SHEET
C0.0

WATerview EAST COMMERCIAL FILING NO. 1

CONSTRUCTION DOCUMENTS
GENERAL NOTES

SHEET
C0.1

WATERVIEW EAST COMMERCIAL
 CONSTRUCTION DOCUMENTS
 GENERAL NOTES

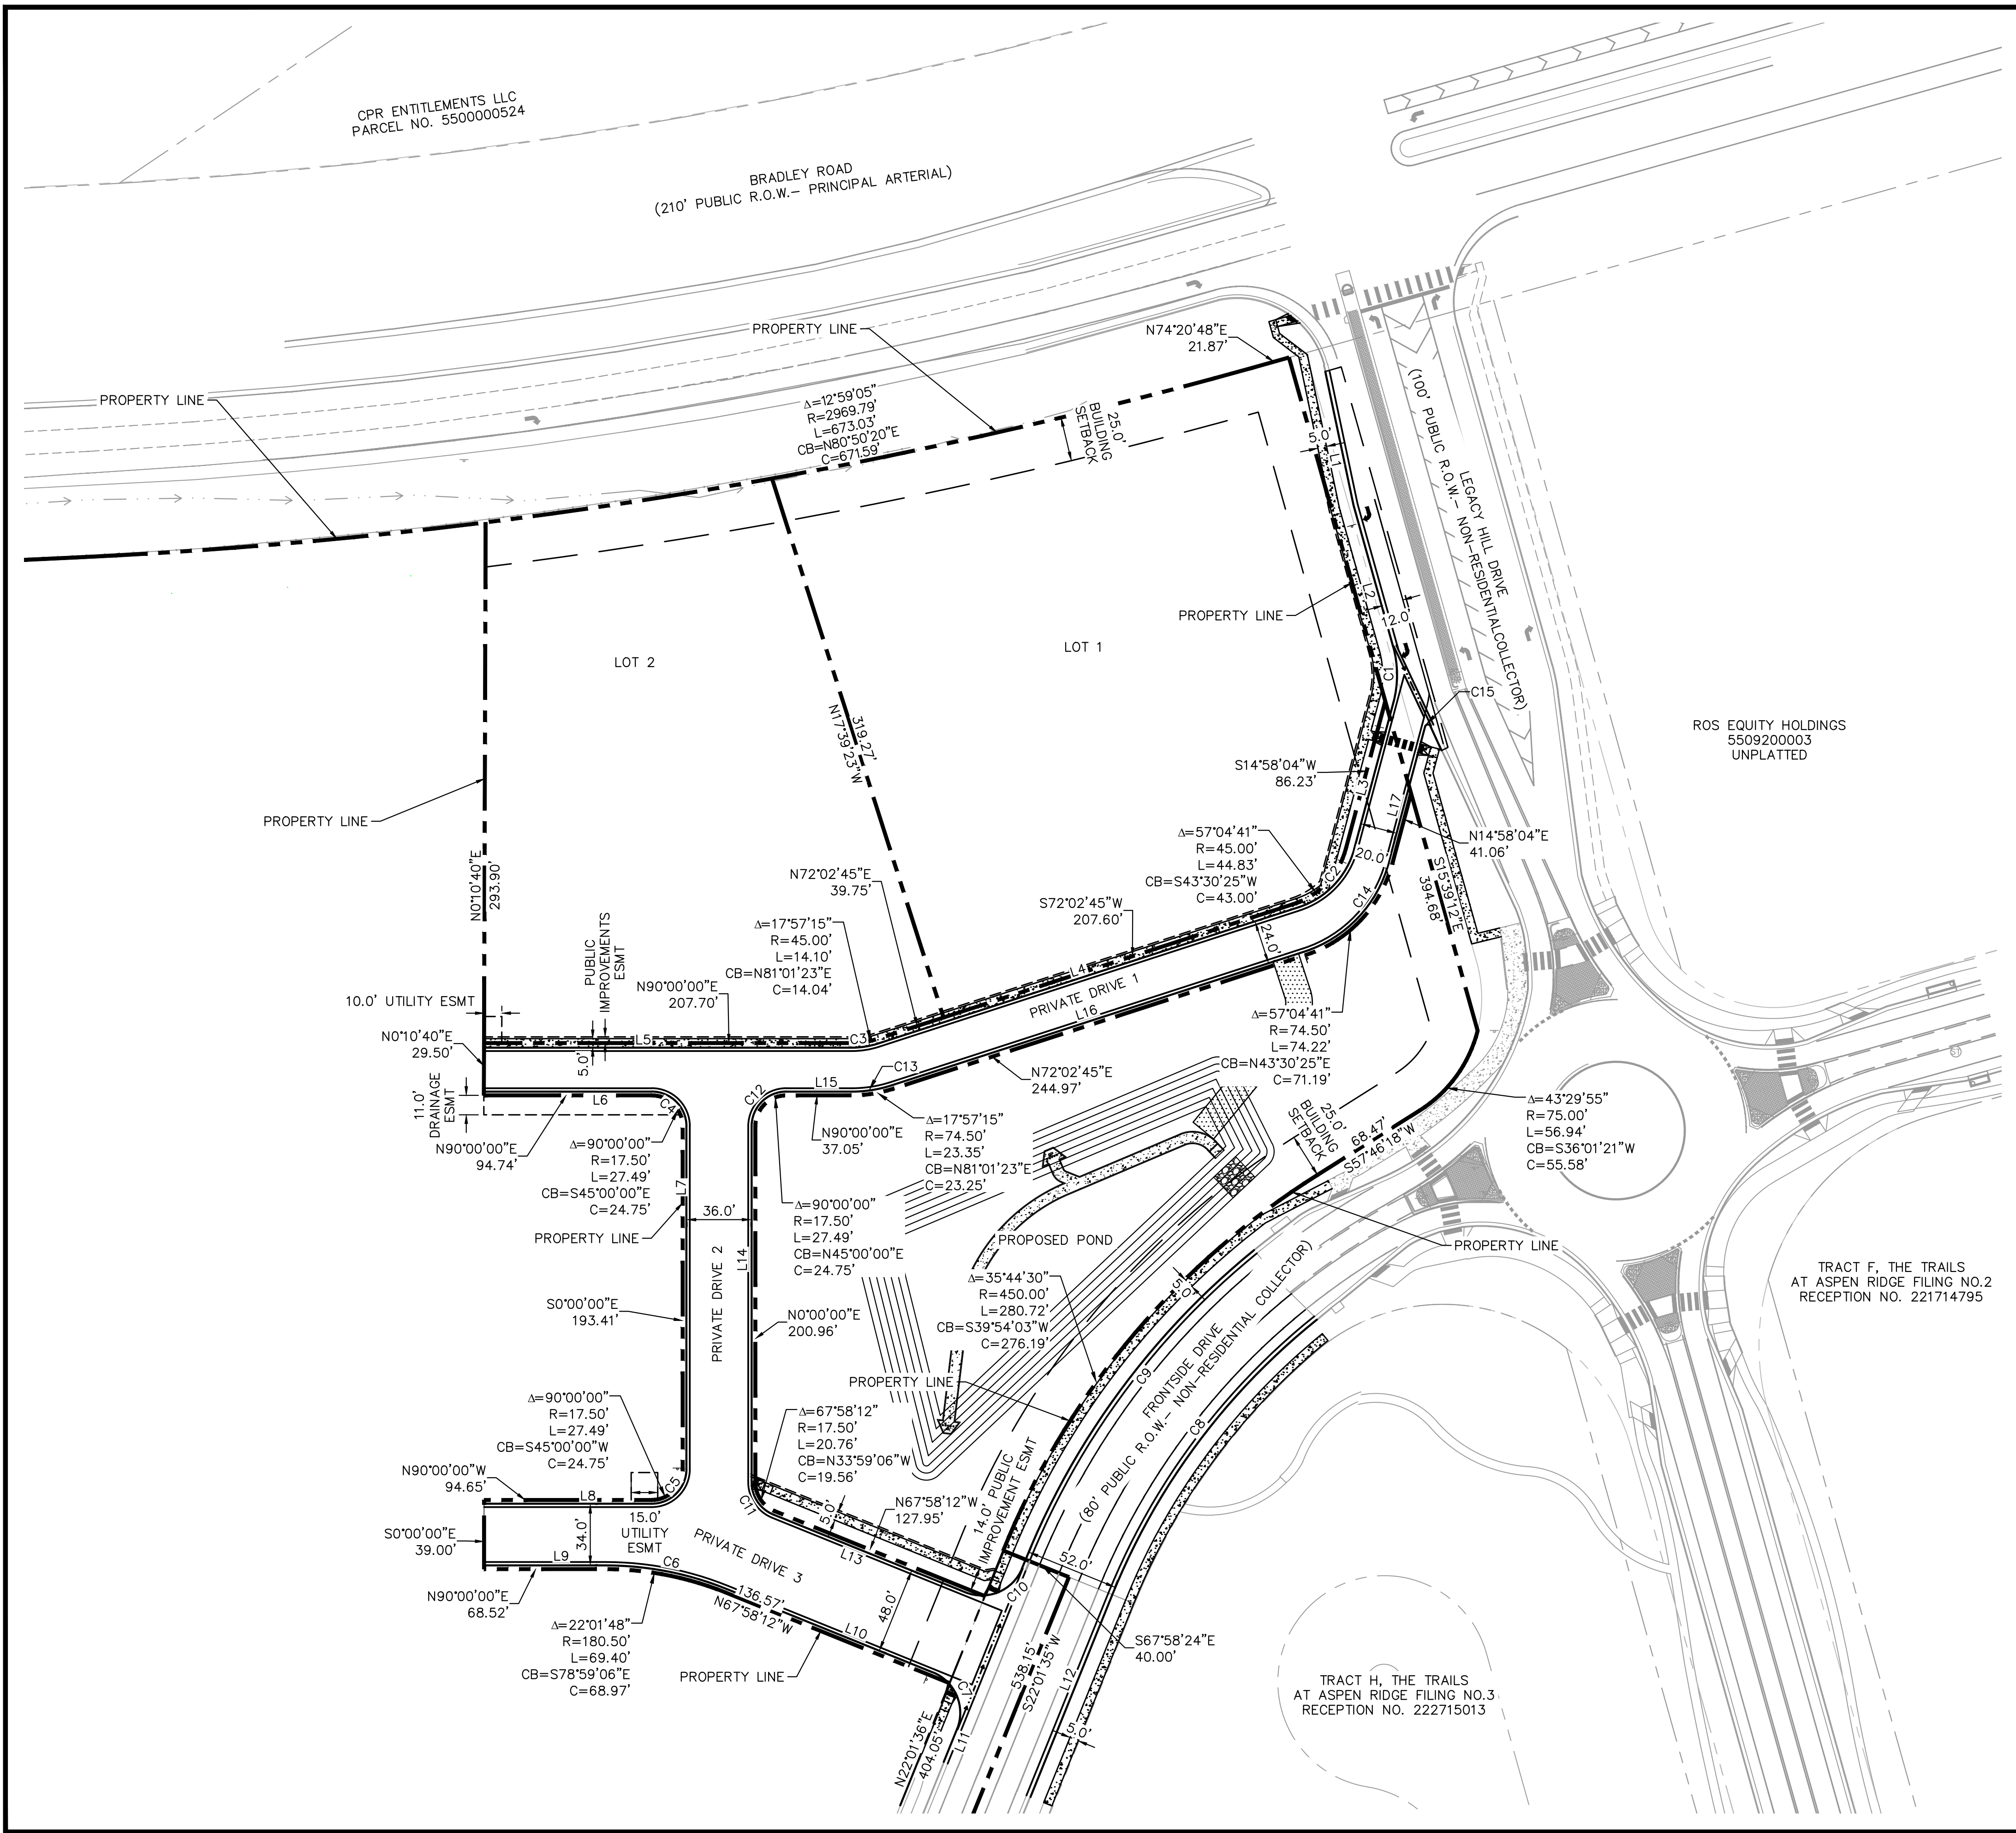
7. THE CONTRACTOR SHALL RESTORE ALL DISTURBED VEGETATION IN KIND, UNLESS SHOWN OTHERWISE.
8. ALL PAVING, CONSTRUCTION, MATERIALS, AND WORKMANSHIP WITHIN THE PUBLIC RIGHT-OF-WAY OR EASEMENT SHALL CONFORM TO THE ~~CITY OF COLORADO SPRINGS'S~~ SPECIFICATIONS AND STANDARDS. (LATEST EDITION)
El Paso County

1. THE ~~CITY~~ OR COUNTY ENGINEER'S SIGNATURE ON THESE PLANS DOES NOT CONSTITUTE APPROVAL OF ANY OF THESE NOTES AND THE ~~CITY~~ WILL NOT BE HELD RESPONSIBLE FOR THEIR ENFORCEMENT.
County

Please replace with most current Signing and Striping Notes (Rev. Oct 2025)

Please update with most current county construction standard notes
